# CITY OF ALBUQUERQUE

July 25, 2018

RE: **Lot 26 Block 6 SAD 228**  
**Volcano Cliffs Subdivision**  
**6209 Papagayo NW**  
**Grading and Drainage Plan**  
**Engineers Stamp Date 7/11/18 (D10D003B26)**  
**CO Certification Dated: 7/23/18**

<div>ENGINEER'S SEAL</div> <div></div> <div>7/11/18</div> <div>DAVID SOULE P.E. #14522</div>	6209 PAPAGAYO ROAD NW	DRAWN BY WCWJ
	GRADING AND DRAINAGE PLAN	DATE 7-10-18
	 1606 CENTRAL AVENUE SE SUITE 201 ALBUQUERQUE, NM 87106 (505) 872-5998	21800-LAYOUT-9-22-17
		SHEET # —
		JOB # 21800

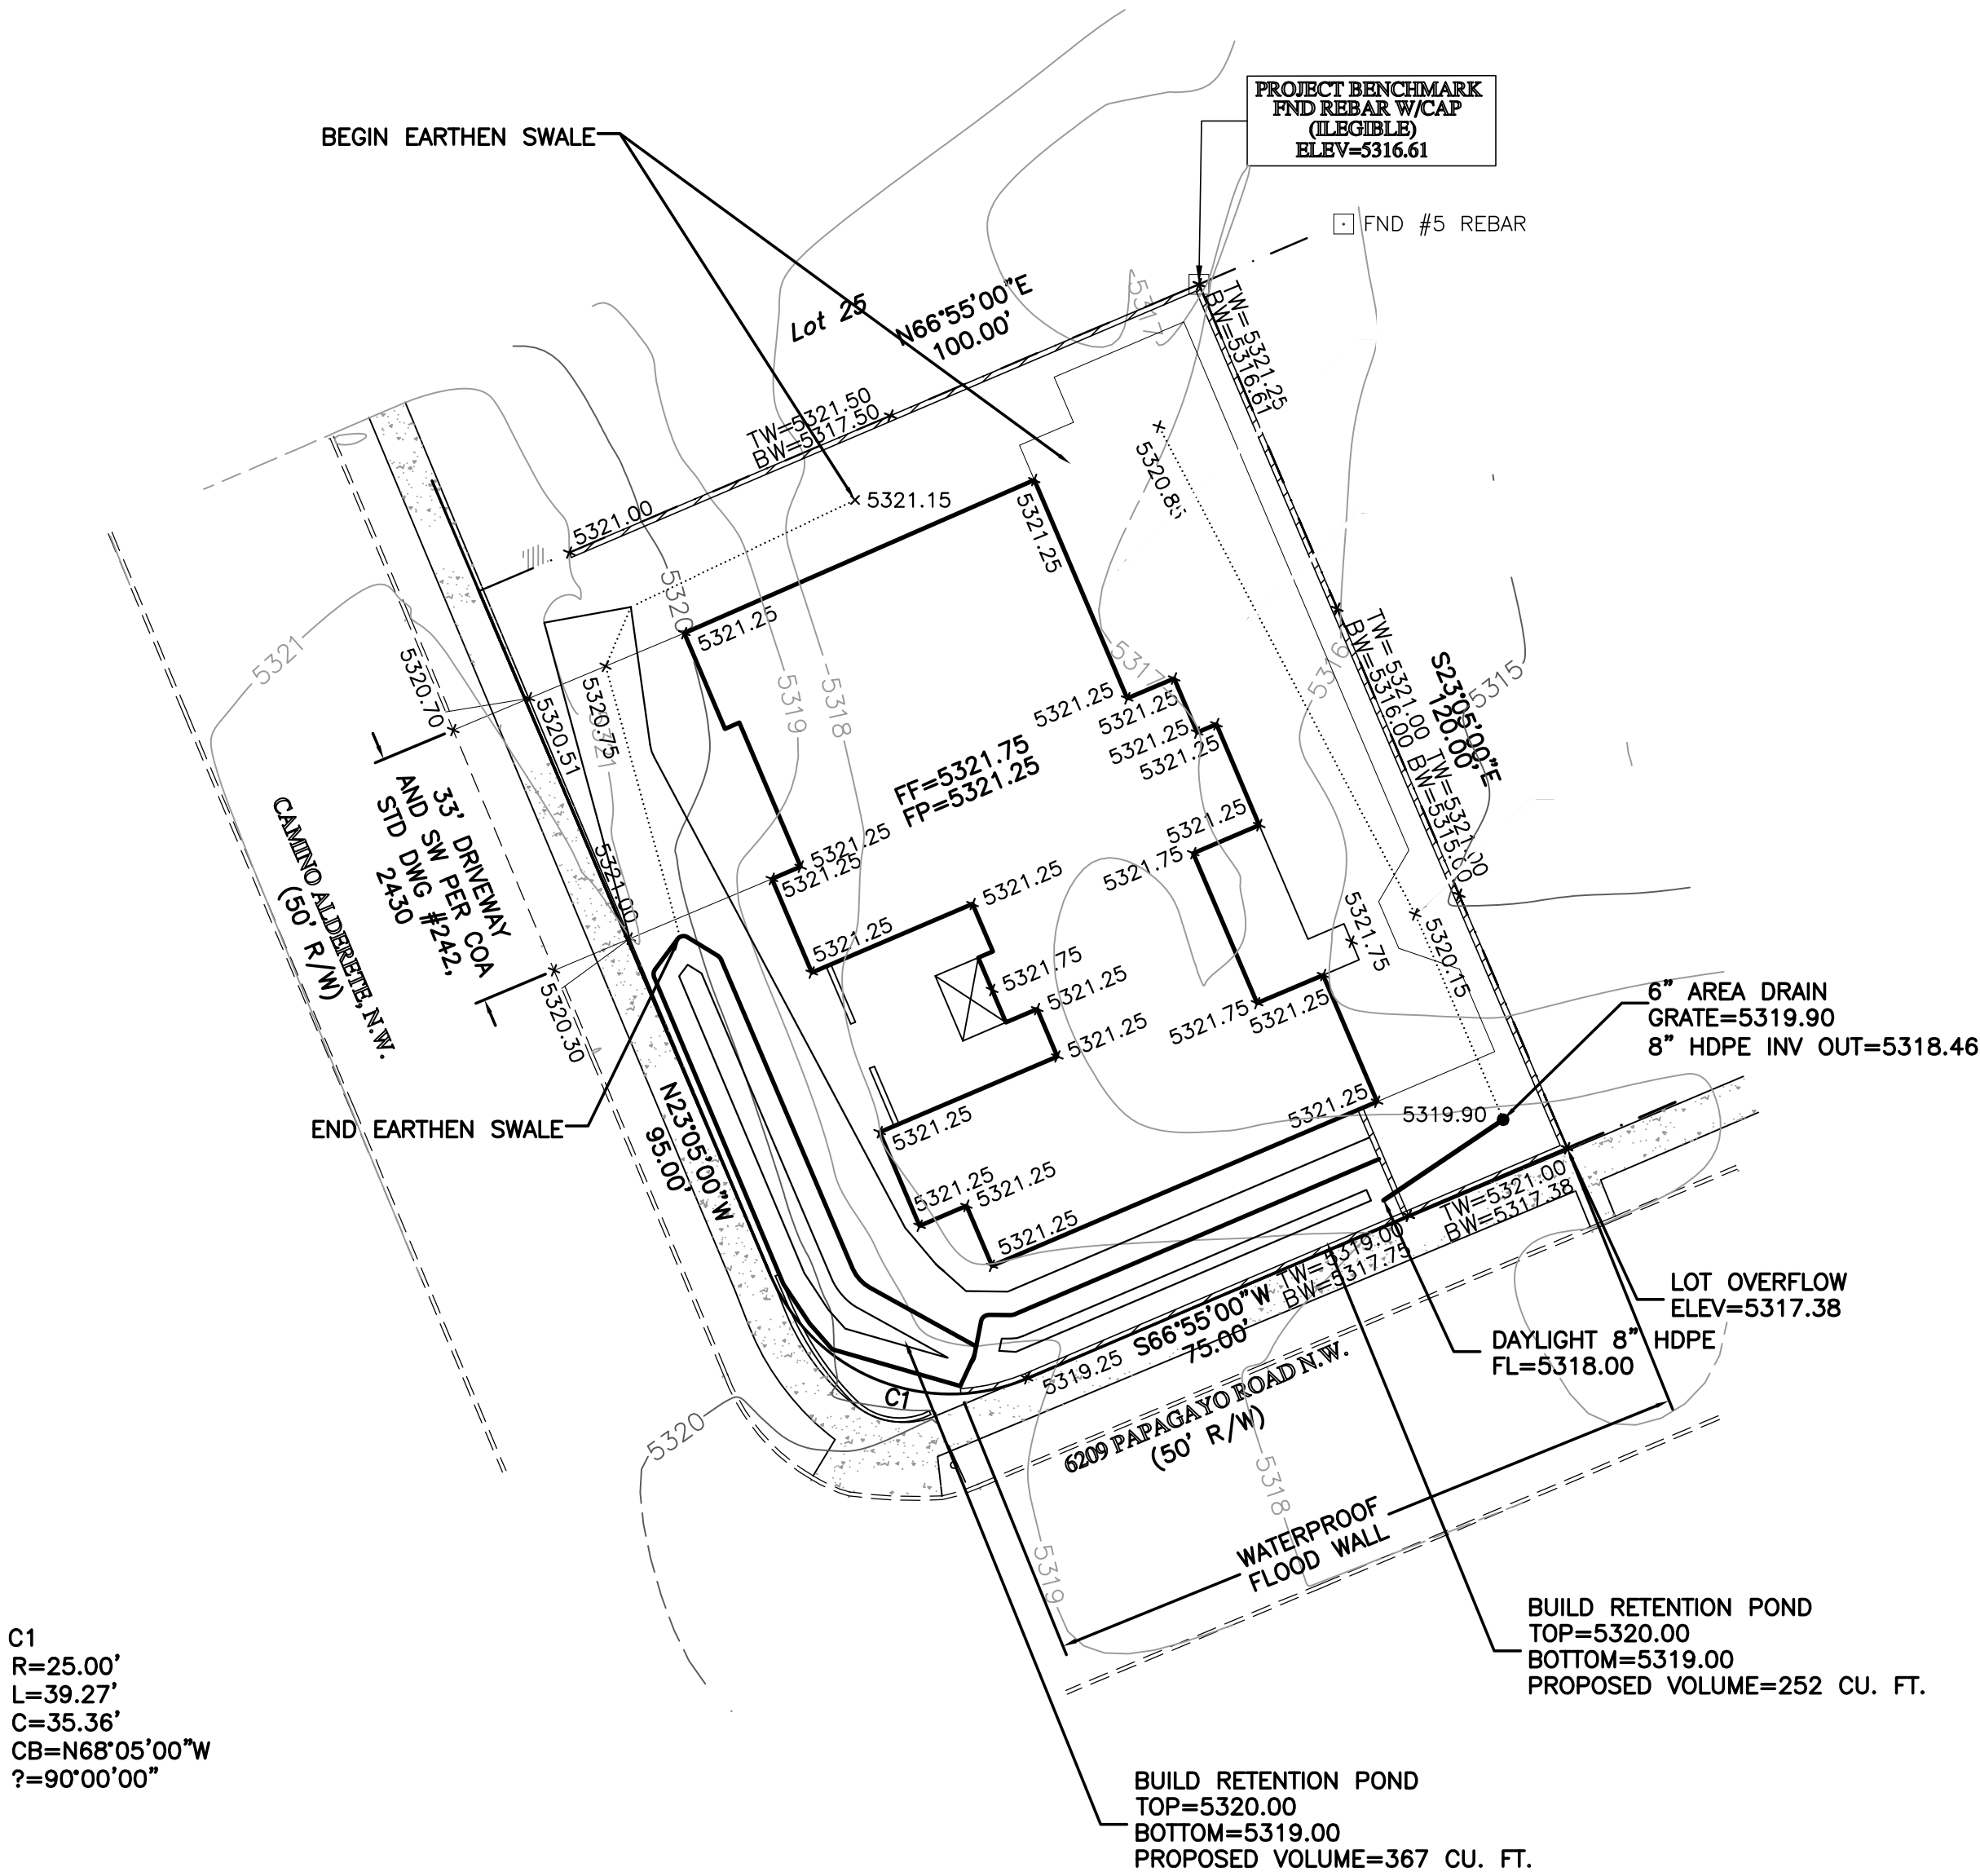
Based upon the information provided in your submittal received 7/23/18, this plan cannot be approved for Certificate of Occupancy until the following comments are addressed.

- Remove the concrete slabs on property to the west of this address.
- Remove all concrete and debris in and around the site.
- Remove the dirt in the streets.
- Opening in front yard garden wall is plugged, clear out the dirt.
- Remove the dirt pile in the front yard.
